ExQ2: 03 August 2021**Responses due by Deadline 7: 03 September 2021**

ExQ2	Question to:	Question:
G.2	General and Cross-topic Questions	
G.2.0	The Applicant	<p>Policy and Need</p> <p>Both in responding to ExQ1s and in evidence at the ISH the Applicant has reaffirmed their view that Government Policy emphasises the urgency of the need for delivery of the project by 2035. The application documentation and the information within the ES sets out a 9-12 year build programme, although the latest Implementation Plan [REP2-044] advises Unit 1 would be operational by the end of 2033, and Unit 2 by mid-2034, with an assumed start date of pre commencement works of quarter 2 (Q2)- 2022. It is understood these dates are based on assumptions that the SoS would make a positive decision on the DCO by end of Q1 2022 and a positive FID by Q3 of the same year. If the Applicant is correct that 2035 is the critical date by which the project must be up and running to meet Government objectives, please answer the following.</p> <ul style="list-style-type: none"> i) What part of 2035 is the critical date 1 January 2035 or 31 December 2035? ii) Does Government Policy specify anywhere a precise date? iii)

DRAWING TITLE:
 SUFFOLK COAST PATH AND FUTURE ENGLAND COAST PATH DIVERSIONS - CONSTRUCTION PHASE

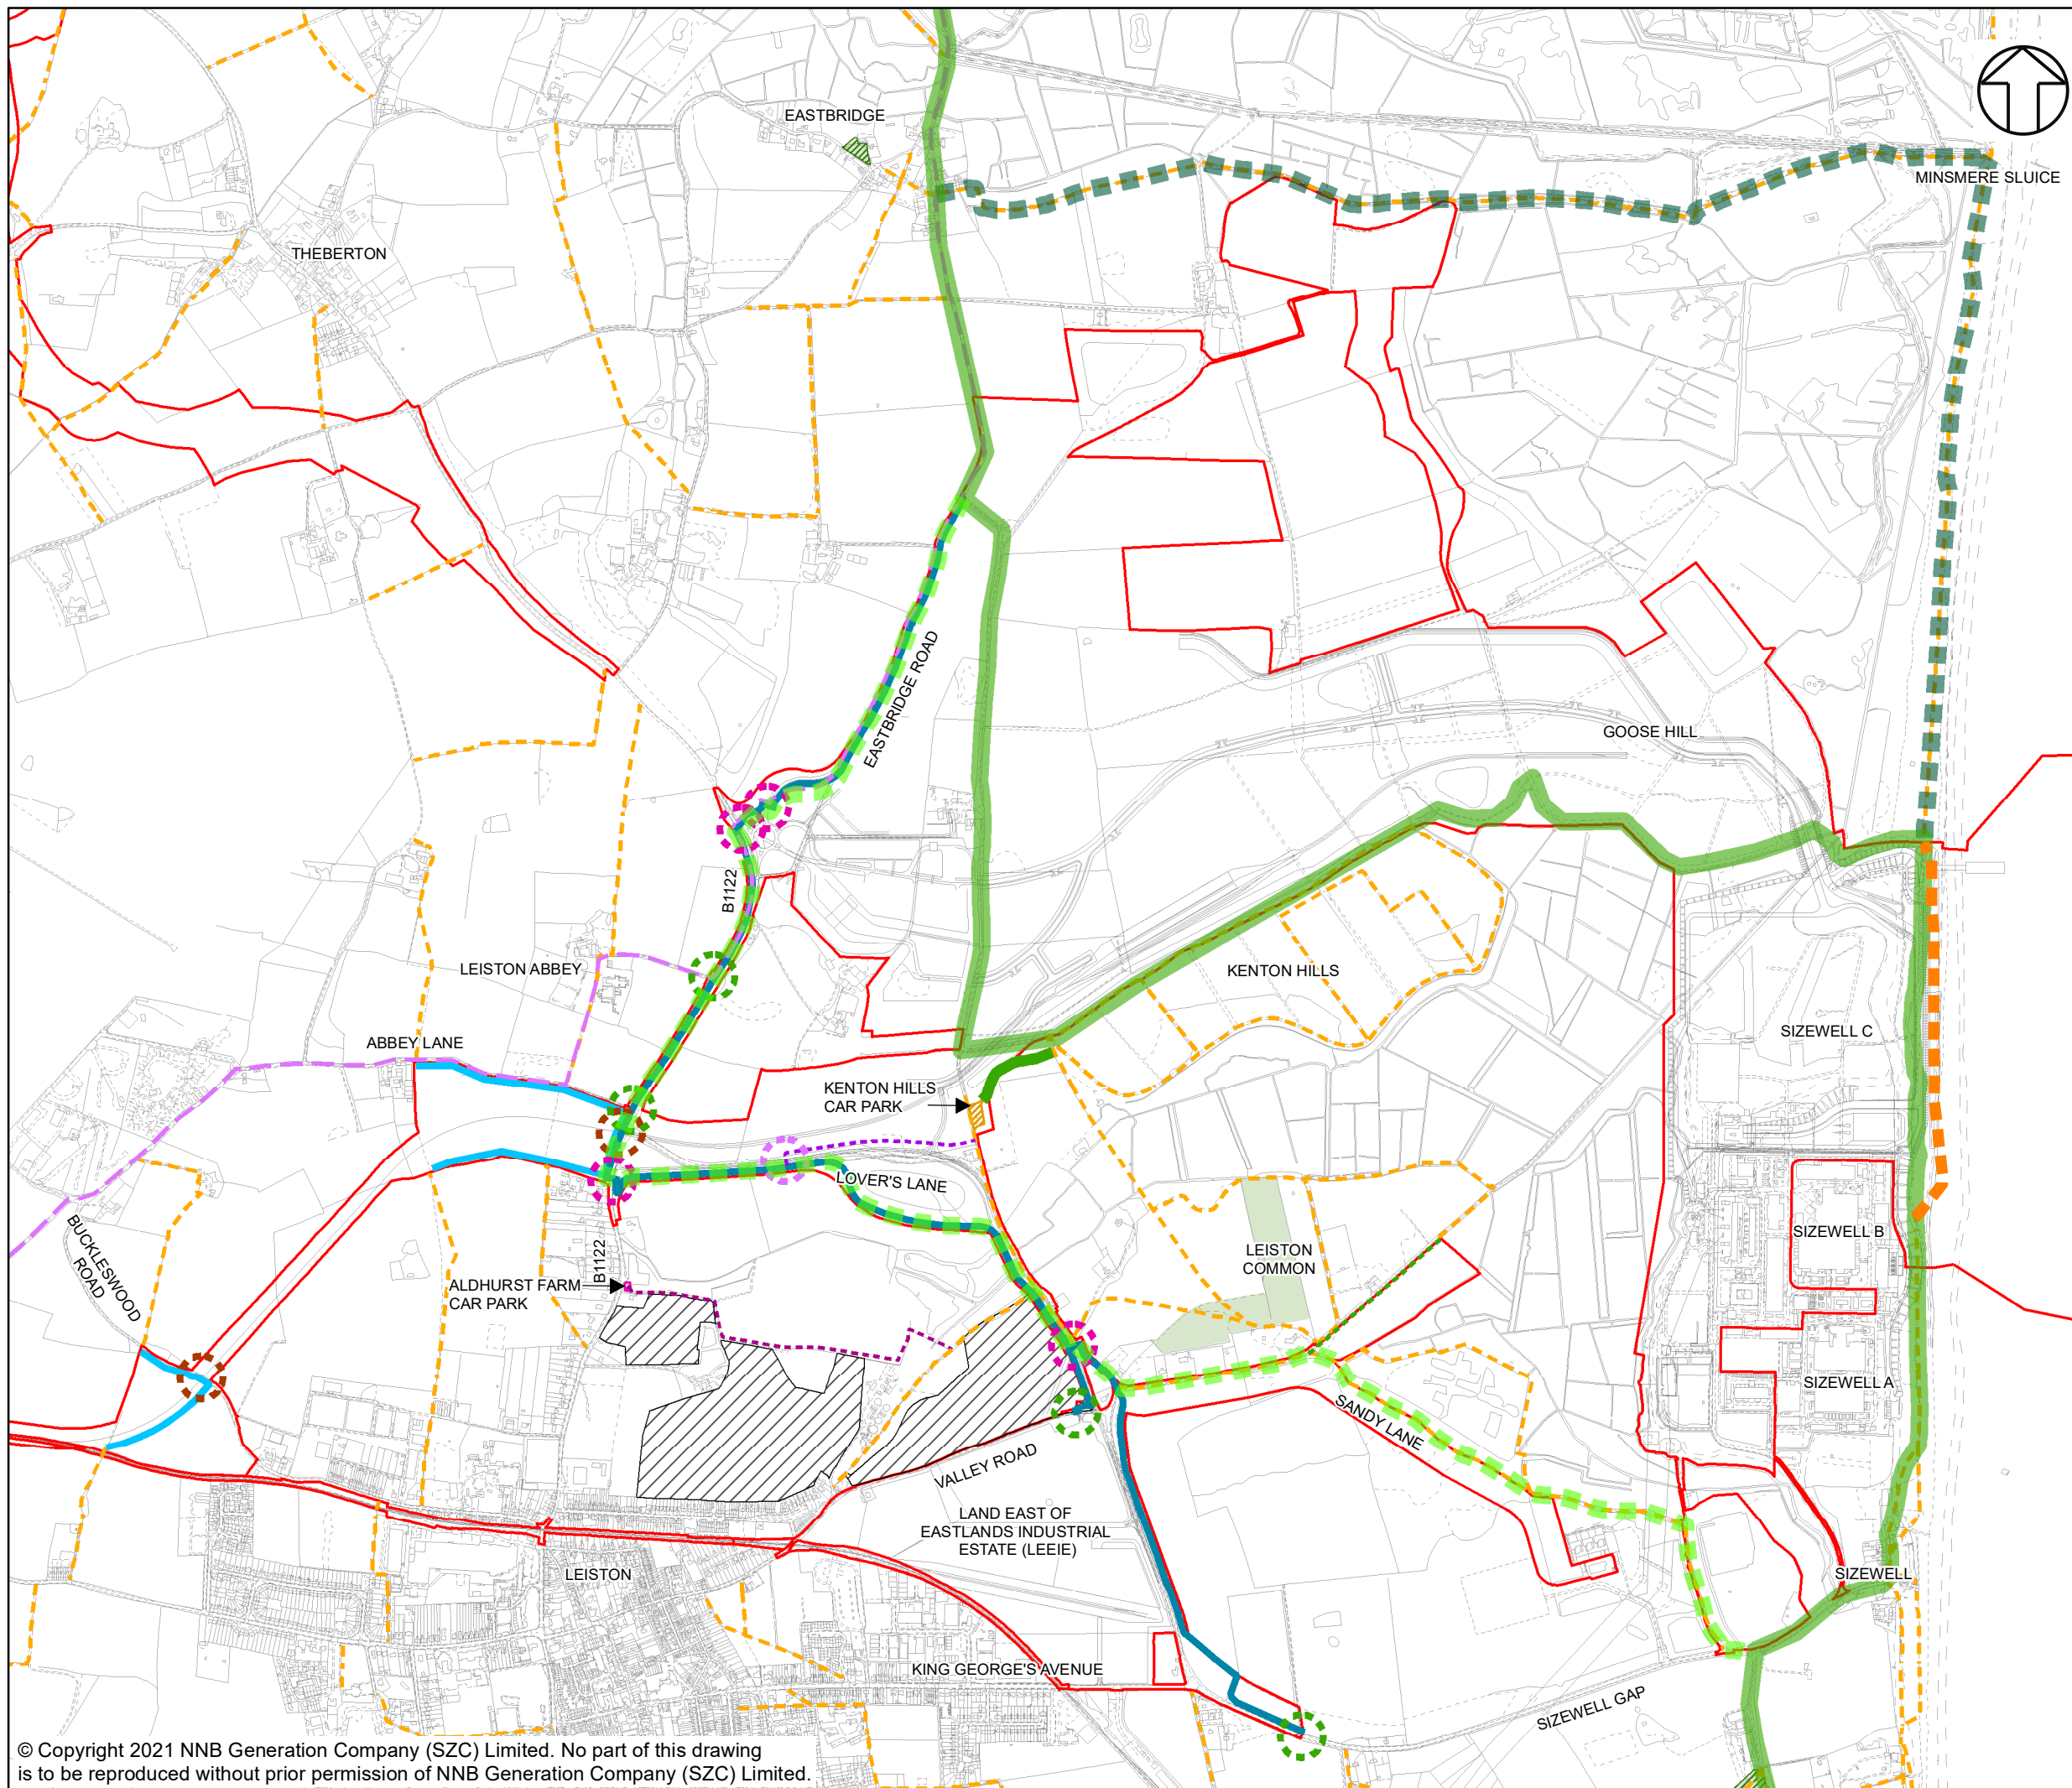
ExQ2	Question to:	Question:
AR.2 Amenity and recreation		
AR.2.0	The Applicant, SCC (point ii and v)	<p>PROW</p> <p>(i) [REP3-013] The Rights of Way Access Strategy provides plans at a very large scale of the existing and proposed coastal path routes, however, the Access and Rights of Way Plans [REP2-007] at a scale of 1:2,500 show greater clarity is it correct to assume the plans shown in [REP2-007] take precedence?</p> <p>(ii) Do SCC seek more detailed plans than those shown in [REP2-007] for the alignment of the coastal path, if so, what scale would you anticipate being appropriate?</p> <p>(iii) In light of the ongoing concerns raised by SCC and supported by ESC in the LIR [REP1-044] and in answer to FWQ AR1.7 what is the current situation with regard to the proposed route of the coastal path and the consequential future maintenance of this important route?</p> <p>(iv) It would appear a further iteration of the Rights of Way and Access Strategy is to be provided to address the concerns raised in the responses to FWQ AR1.7, while a revised version has been received [REP3-013] this does not appear to respond to the points referred to by SCC and responded to in the WR response from the Applicant. When is this proposed to be submitted to the Examination?</p> <p>(v) Has clarification been provided from SCC regarding <i>"the changes proposed for the management of access to the coast"</i> in their response to AR1.7?</p>
